Rezoning Transportation Analysis

Petition Number: 2021-160

Date	Description
08-20-2021	First Review (WB)

RZ - 2

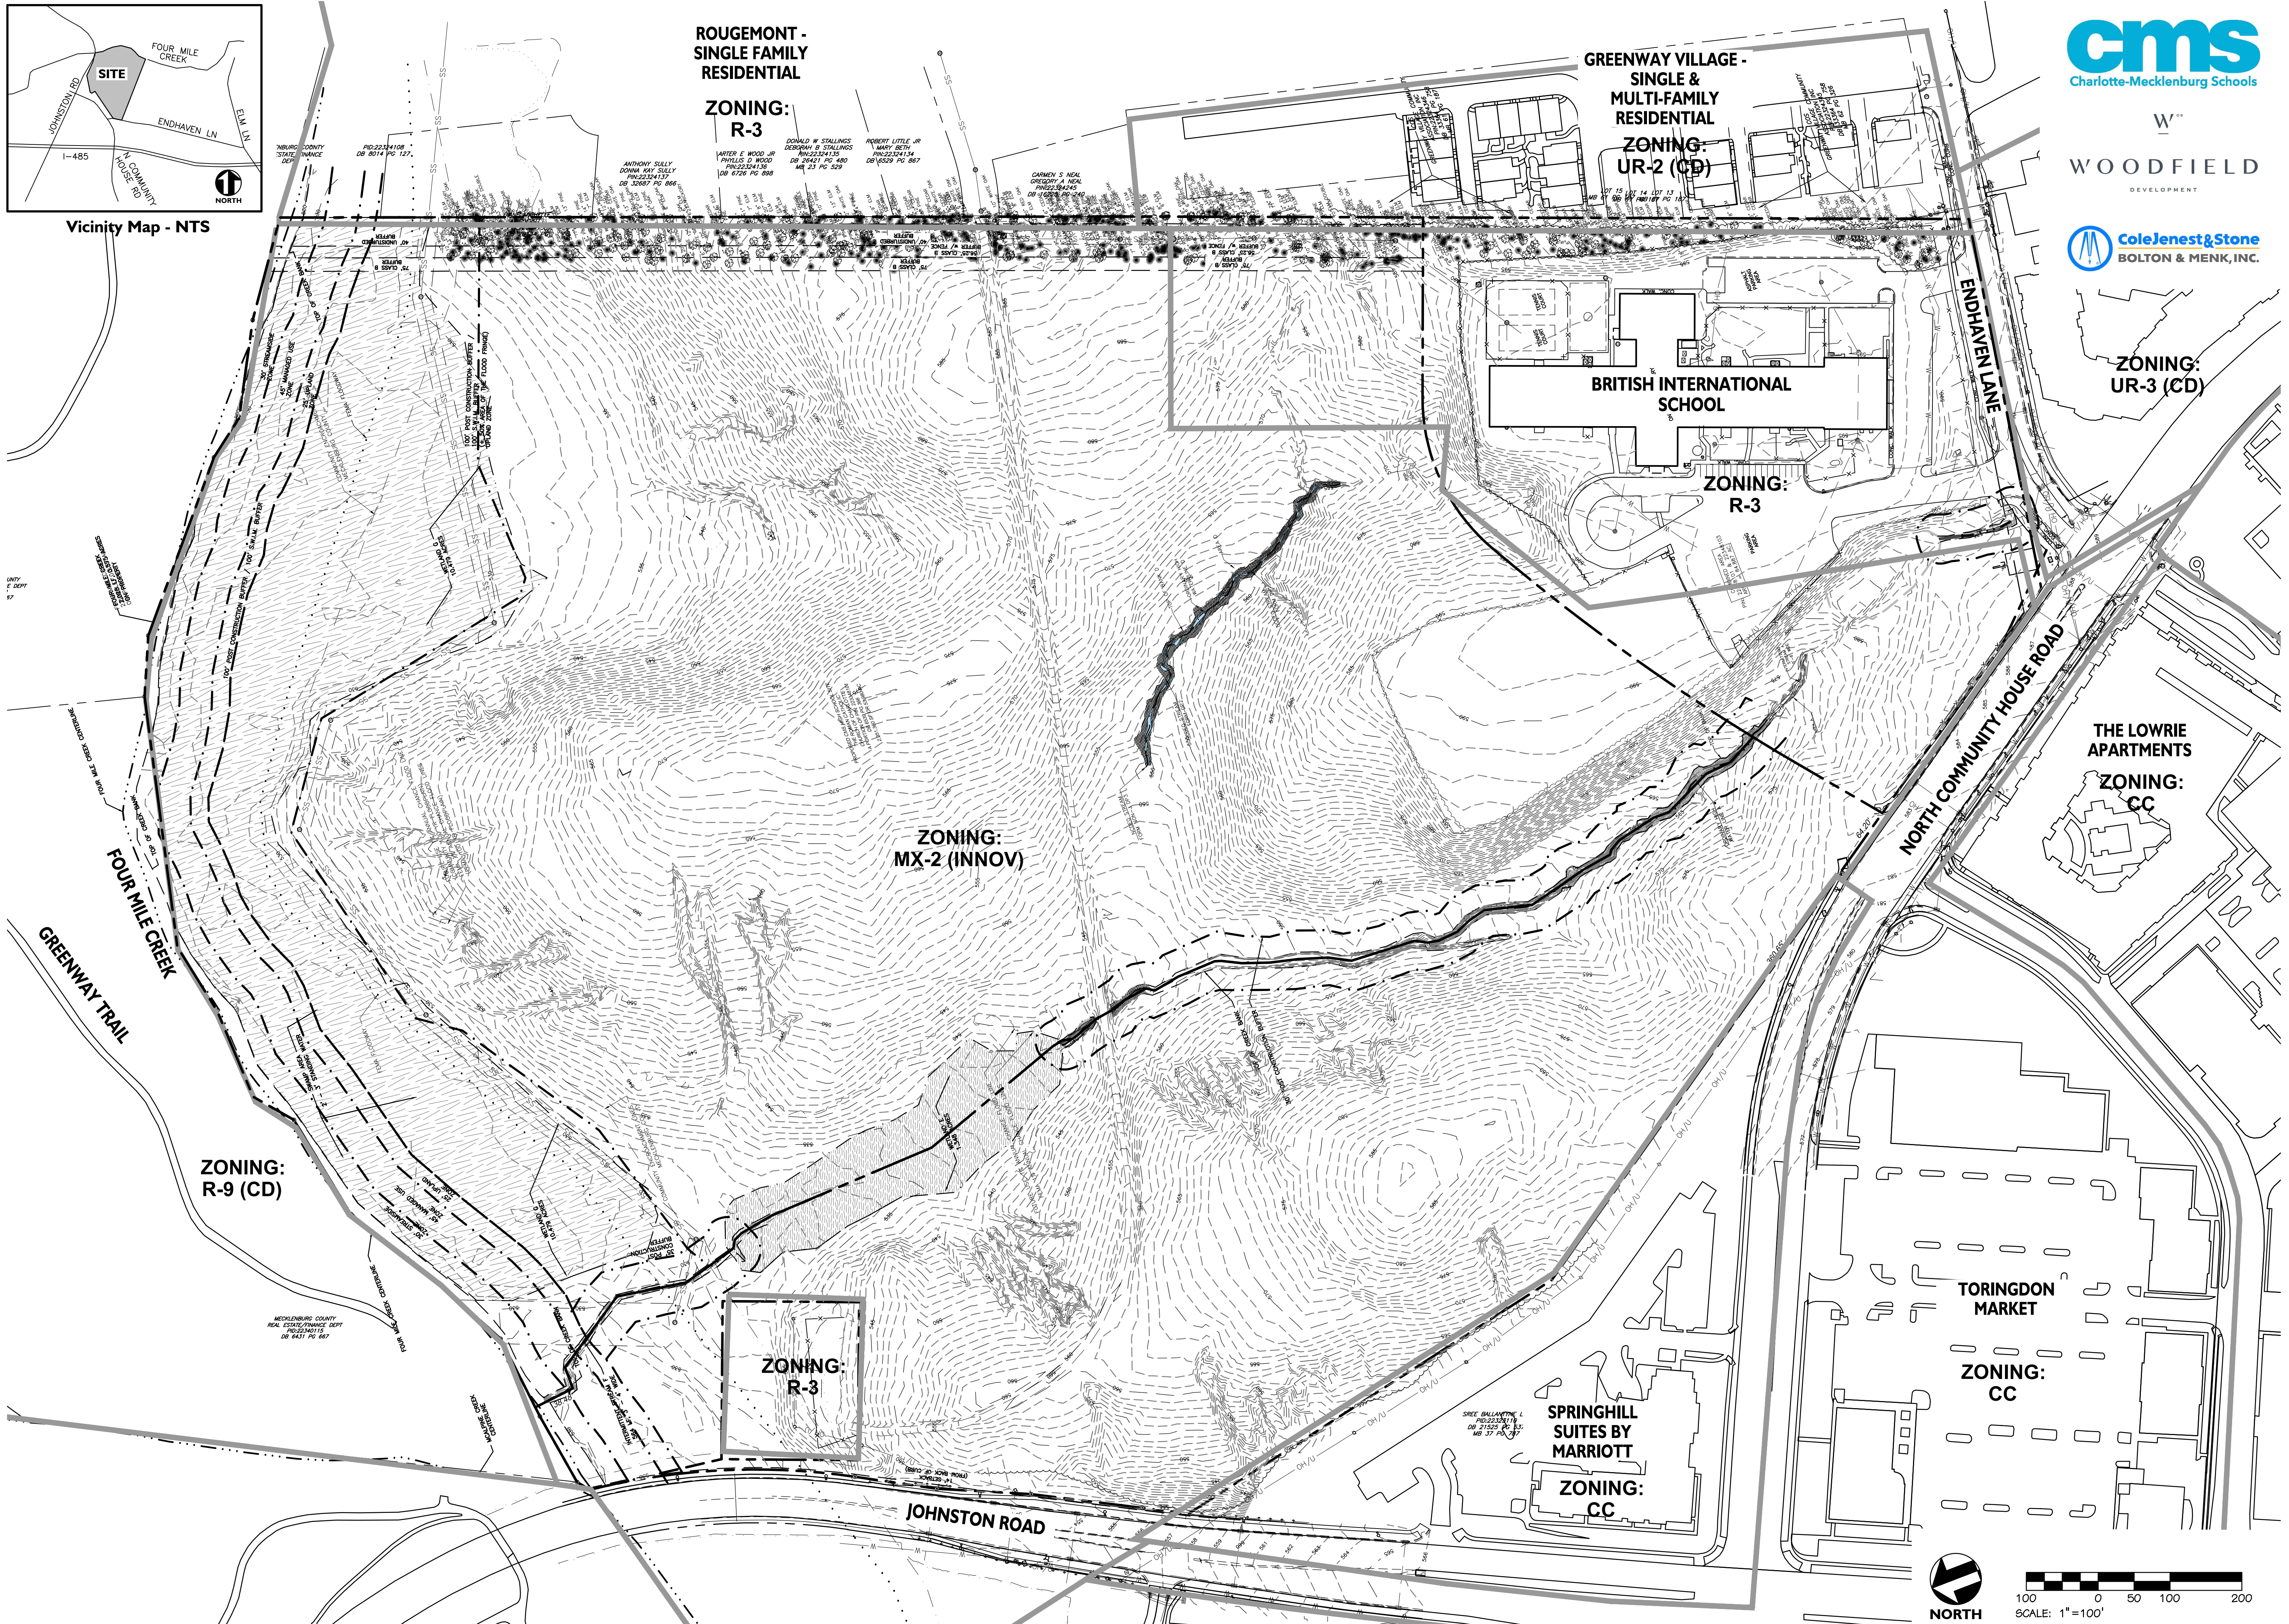
Label and dimension the curb and gutter from the centerline for each road on the site plan.

3. Site plan and conditional note(s) revisions are needed to commit to construct a 12' multi-use path from the Barrette Place Stub into the site and northward, toward the greenway, in accordance with the Charlotte BIKES and Charlotte WALKS Plans.
